The Secretary
NSW Department of Planning, Industry and Environment

7 August 2021

I refer to the Department's below email of 2 August 2021 regarding the notice of exhibition of the Environmental Impact Statement (EIS) for State Significant Development SSD-15882721 Doran Drive Plaza Precinct for Construction of a 20-storey mixed-use development, comprising retail, commercial and community spaces, 431 residential units and a public plaza at 2 Mandala Parade, Castle Hill (Lot 55 DP 1253217) in The Hills Shire Council Local Government Area. Submissions need to be made to the Department by 30 August 2021.

Scale
1:200 @A1, 50% @A3
Status
DA Submission
Project No.
19068
Dwg No.
DA-110-100
Drawn by
AM_VL_A_E
Rev
04
North

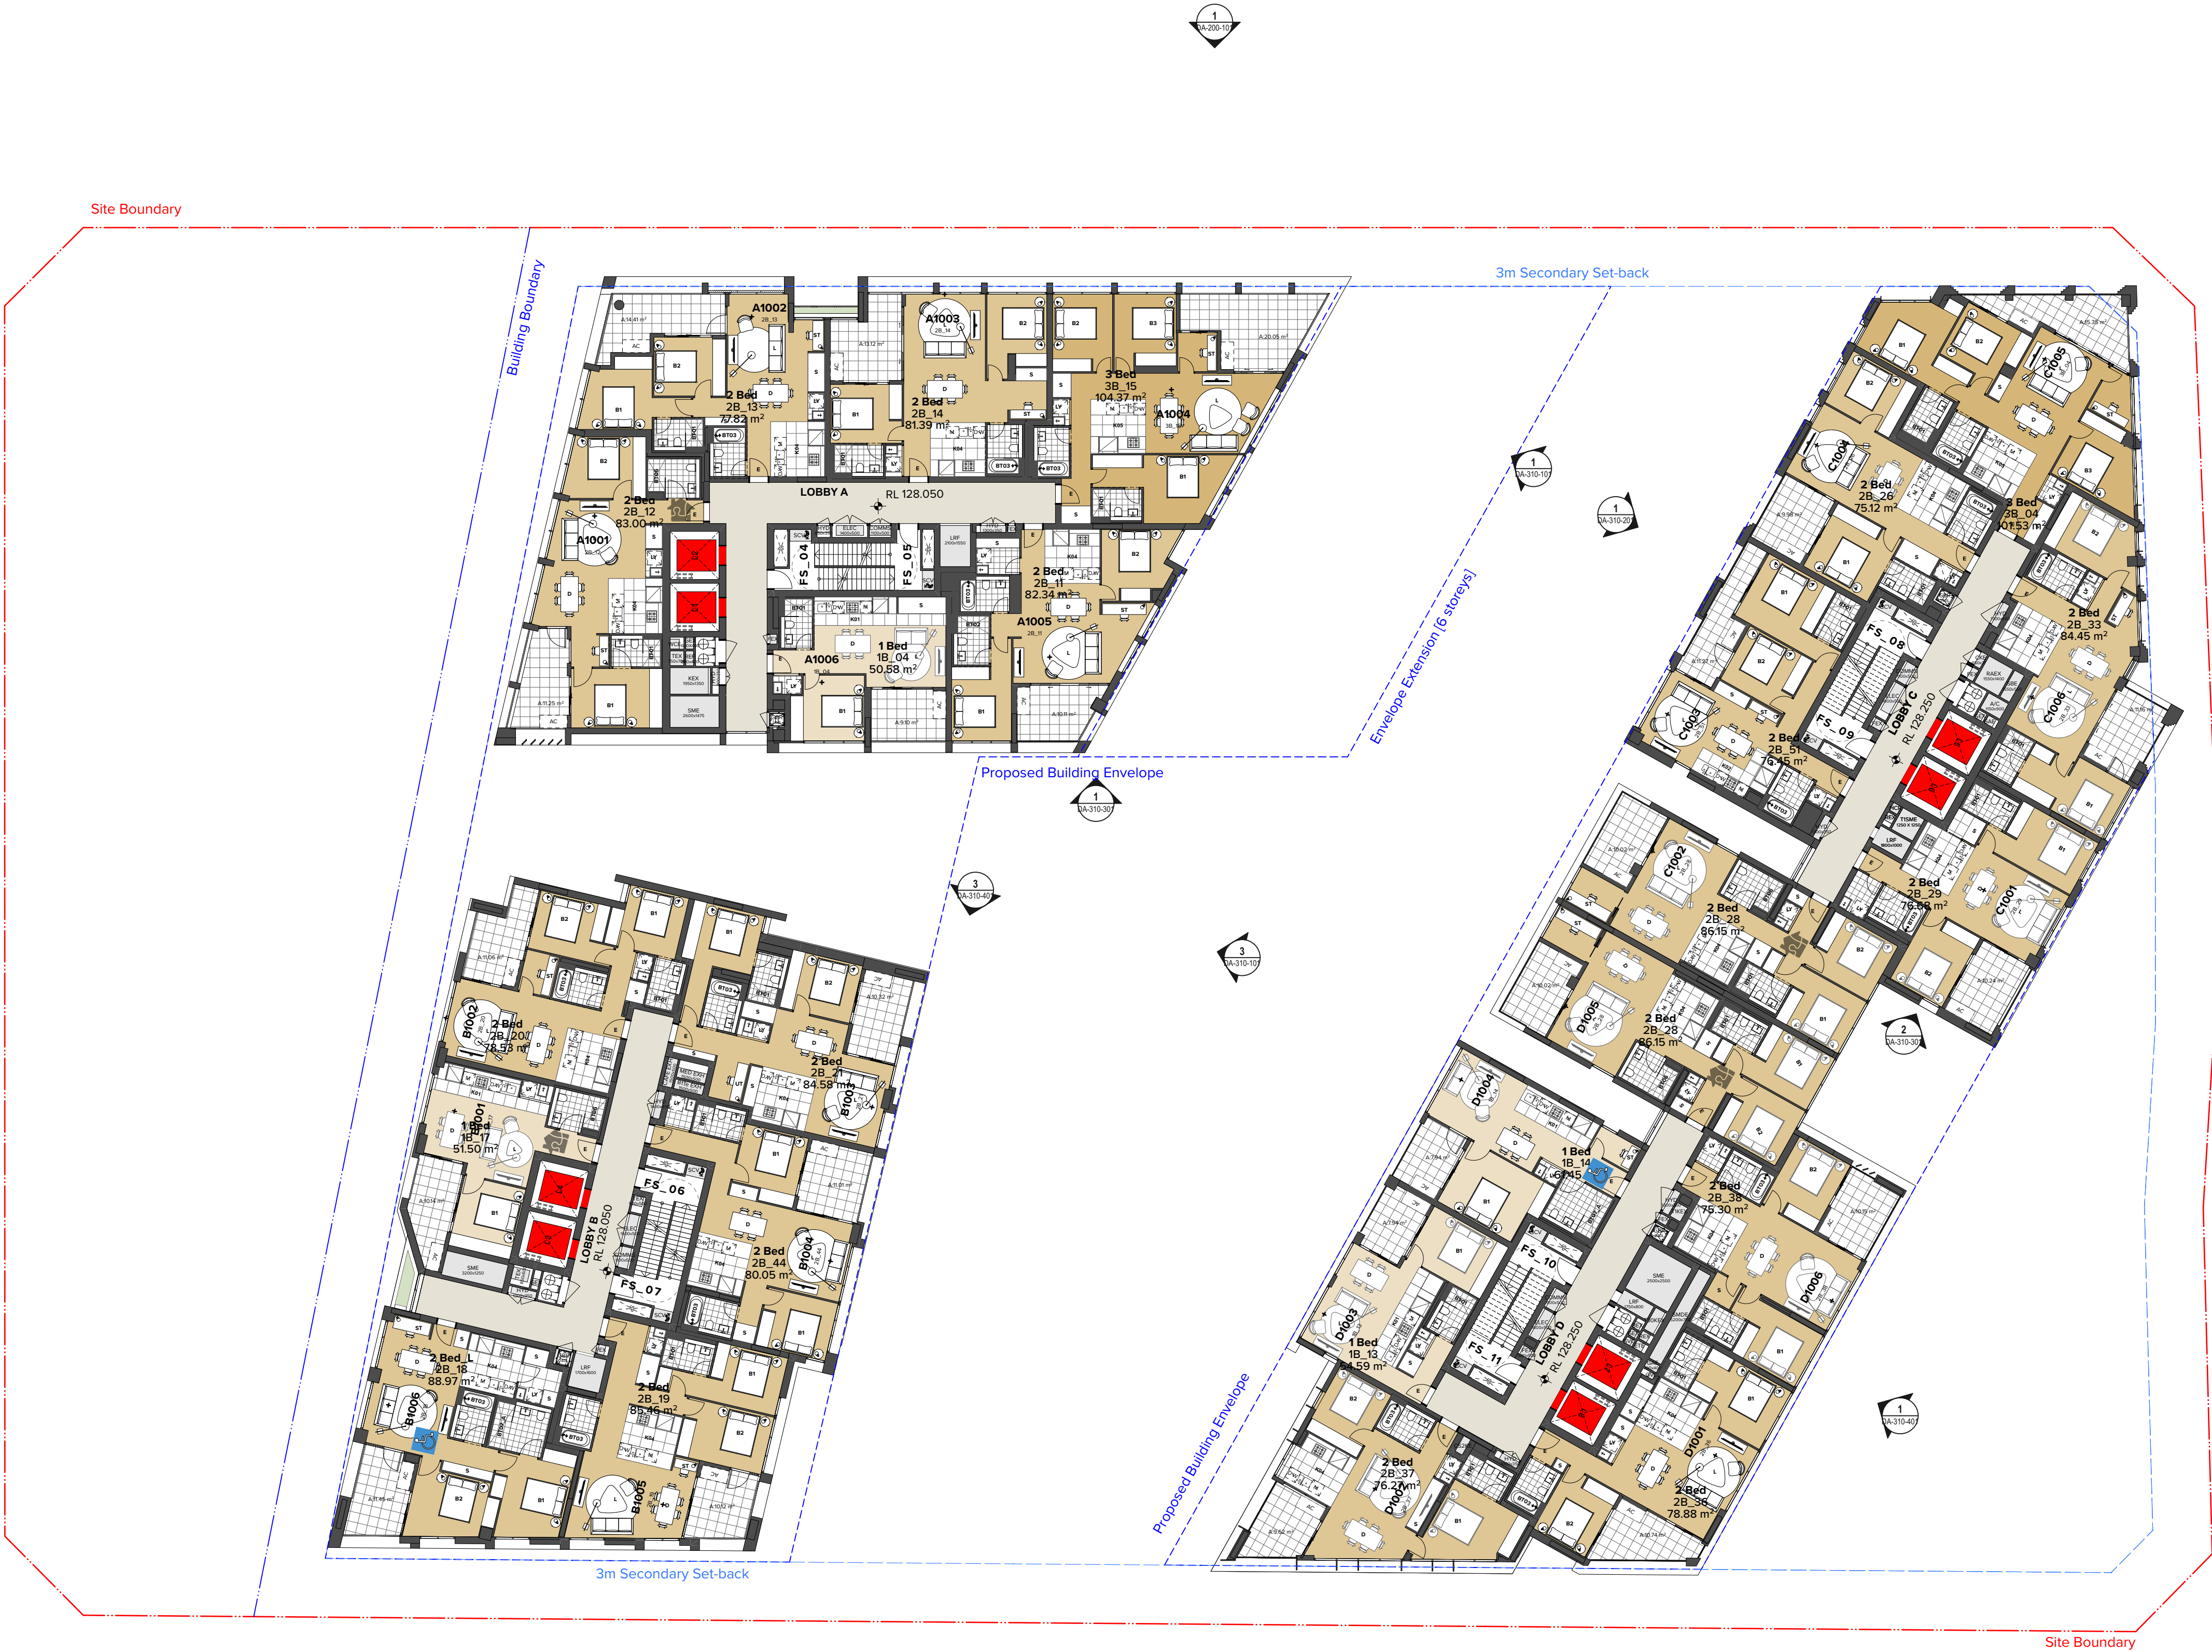
Endeavour Energy has noted the Statement of Environmental Effects indicates there is a '0 metre podium setback (northern and western street frontages)' as well as 'The proposed awning will have a width of approximately 3m. The awning has been extended to the corner of Prince Street and Third Avenue' which is shown in the following extract of the Level 1 plan.

As shown in the following extracts of the Architectural Plans there is provision for an indoor substation to the north eastern corner of the Andalusian Way frontage.

From Endeavour Energy's perspective the fact that provision is being made for an indoor substation is a positive. Endeavour Energy's general requirements is for an indoor substation to be at ground level and have direct access from a public street.

As shown in the following Clause 5.3.5 'Indoor substations', from Endeavour Energy's Mains Design Instruction MDI 0044 'Easements and Property Tenure Rights', indoor substations require the following:

5.3.5 Indoor substations

The boundaries of an easement for indoor substation must be defined by the internal face of the walls, ceiling, floor, and cable trenches of the substation room.

An easement for the cables that enter and exit the substation room will also be required if they are not installed within public roads and/or existing Endeavour Energy easements.

A right of access may also be required to give Endeavour Energy employees, vehicles, and equipment unrestricted access to the indoor substation at all times.

Generally it is the Level 3 Accredited Service Provider's (ASP) responsibility (engaged by the developer) to make sure that the substation location and design complies with Endeavour Energy's standards the suitability of access, safety clearances, fire ratings, flooding etc. As a condition of the Development Application consent Council should request the submission of documentary evidence from Endeavour Energy confirming that satisfactory arrangements have been made for the connection of electricity and the design requirements for the substation, prior to the release of the Subdivision Certificate / commencement of works.
